PROJECT TITLE: 120 MORNINGSIDE WAREHOUSE ADD.
DRB #: PC#:

CITY OF ALBUQUERQUE

Re: Warehouse Addition Grading Plan Certification
120 Morningside Dr. SE
Engineer Cert Stamp dated 9-21-09 (K17/D87)

GRADING & DRAINAGE PLAN

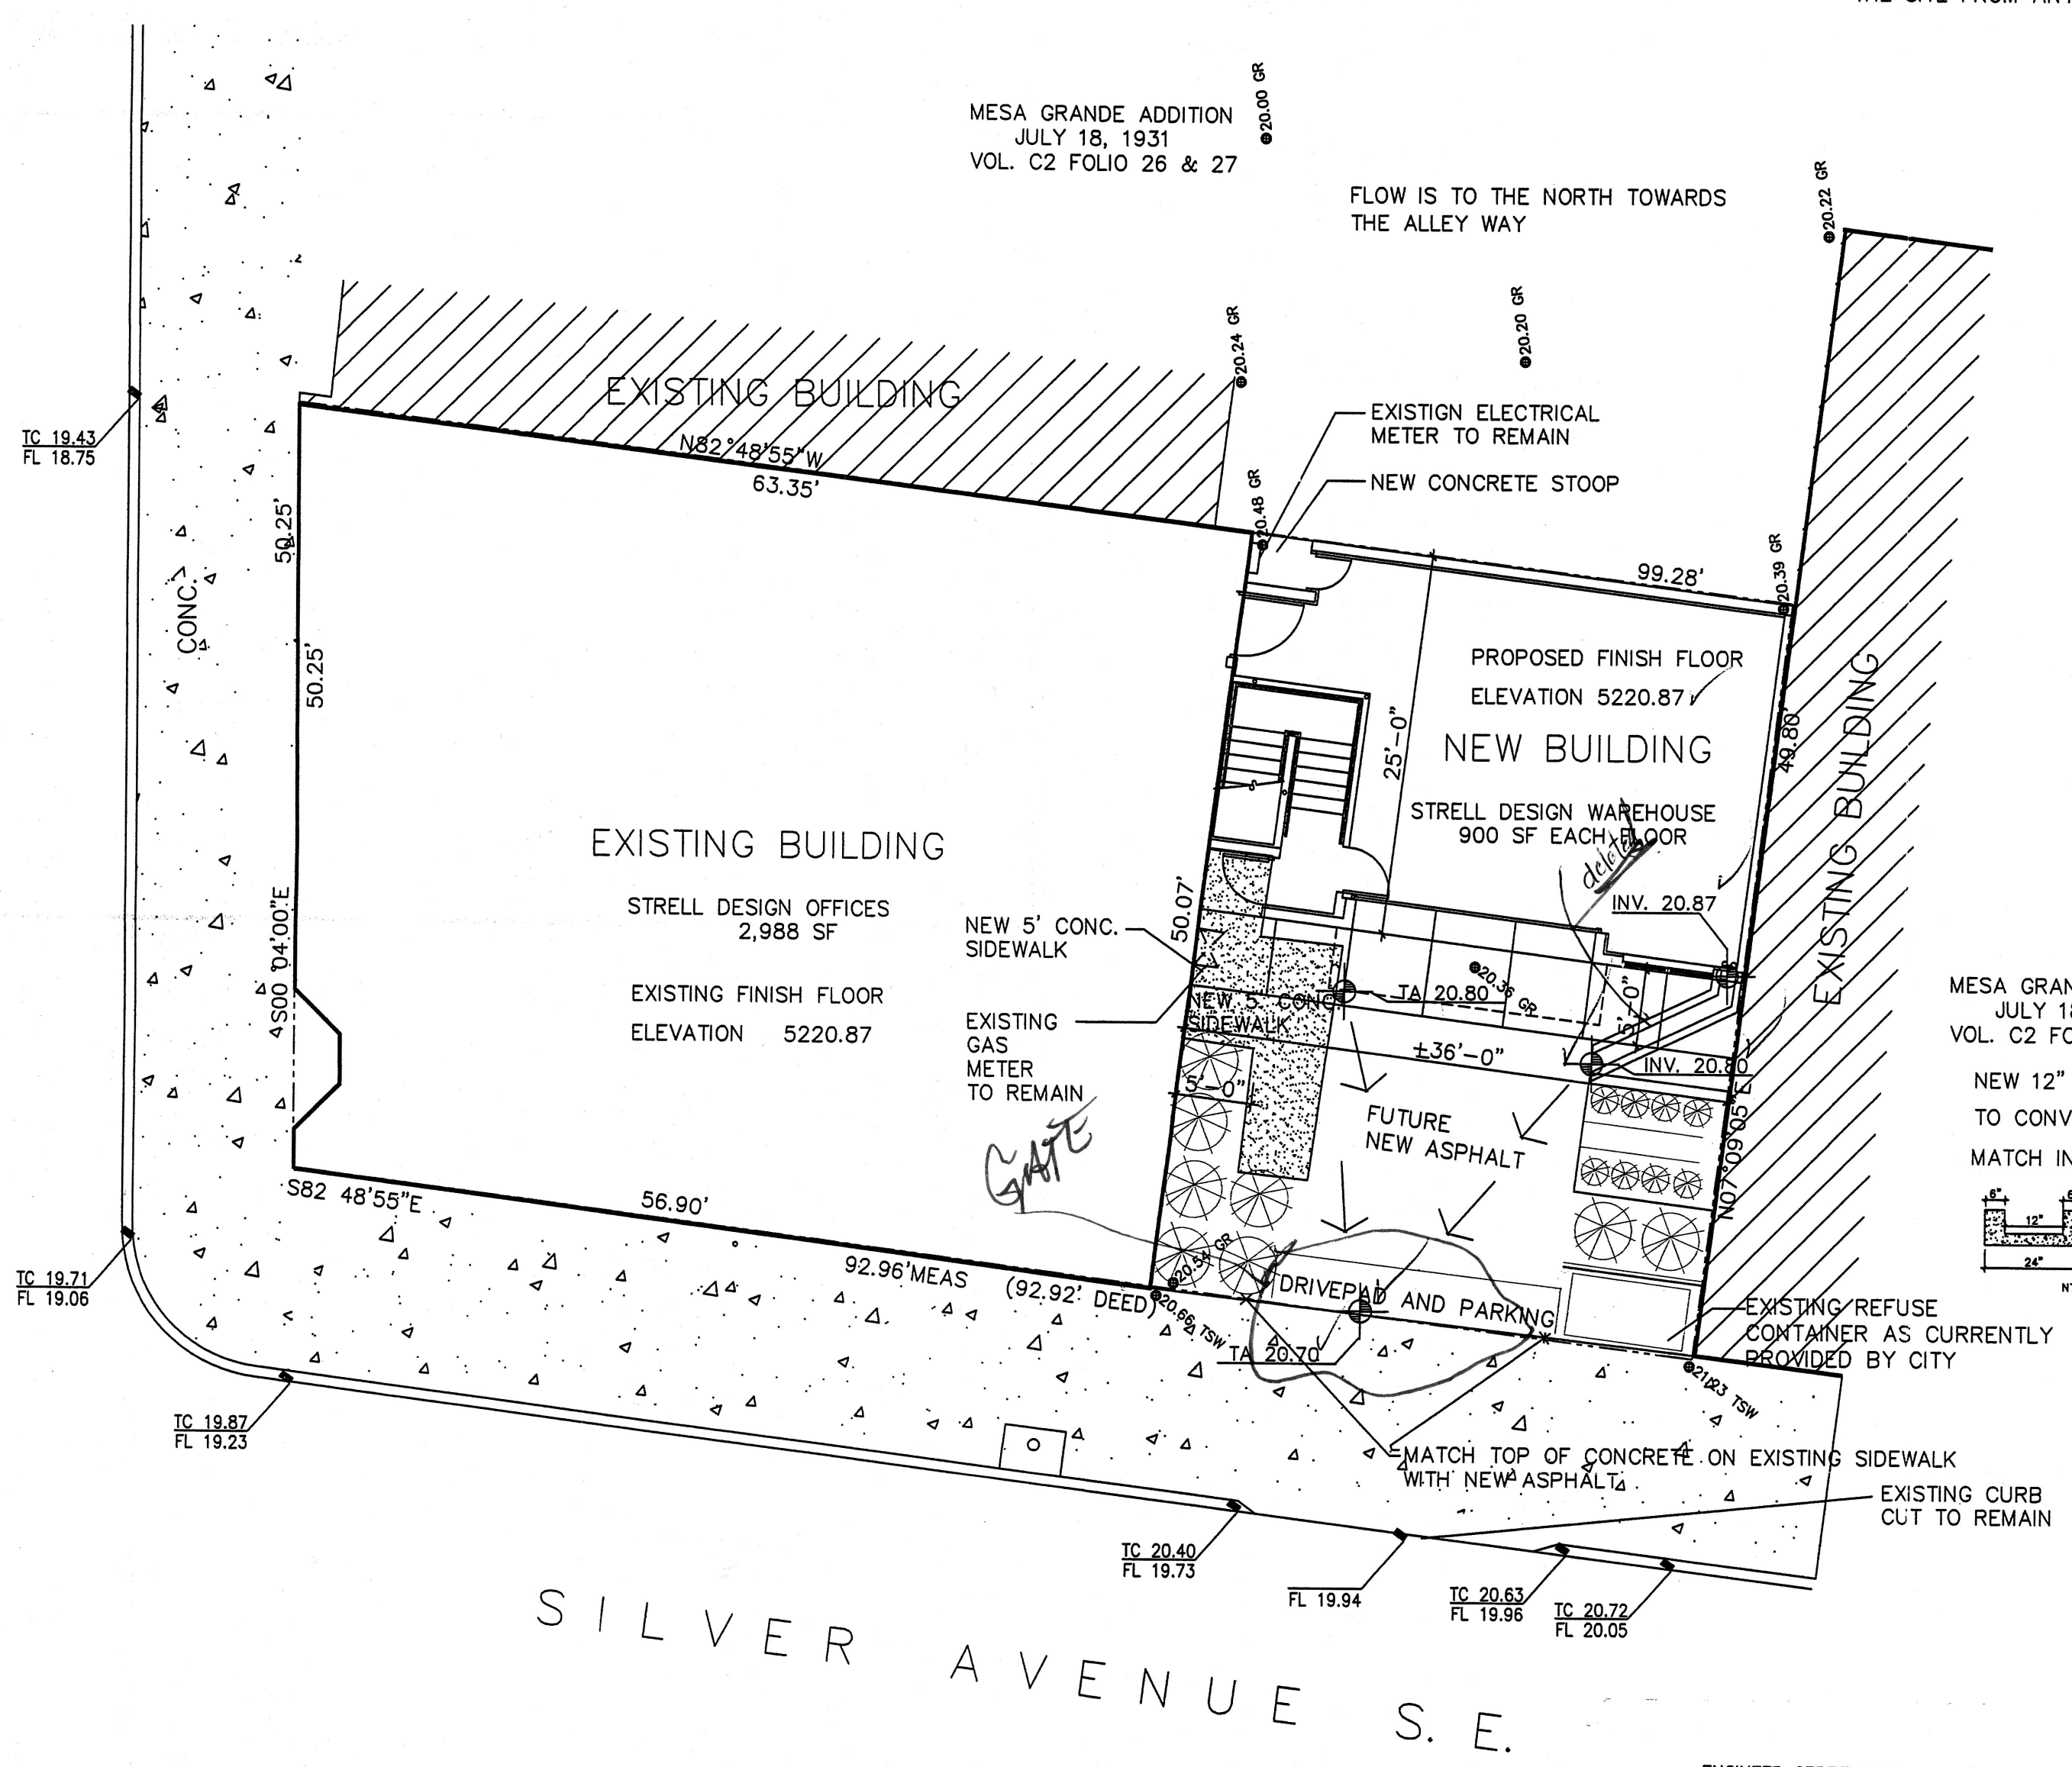
- The rundown in NE corner of the plaza was shown as deleted and this rundown is an integral feature of the drainage plan; it was needed to convey water away from the building. It is likely that water will pond adjacent to the addition and could cause issues with the foundation. If your client and the adjacent owner acknowledges this fact and will do so in writing, it could be allowed.
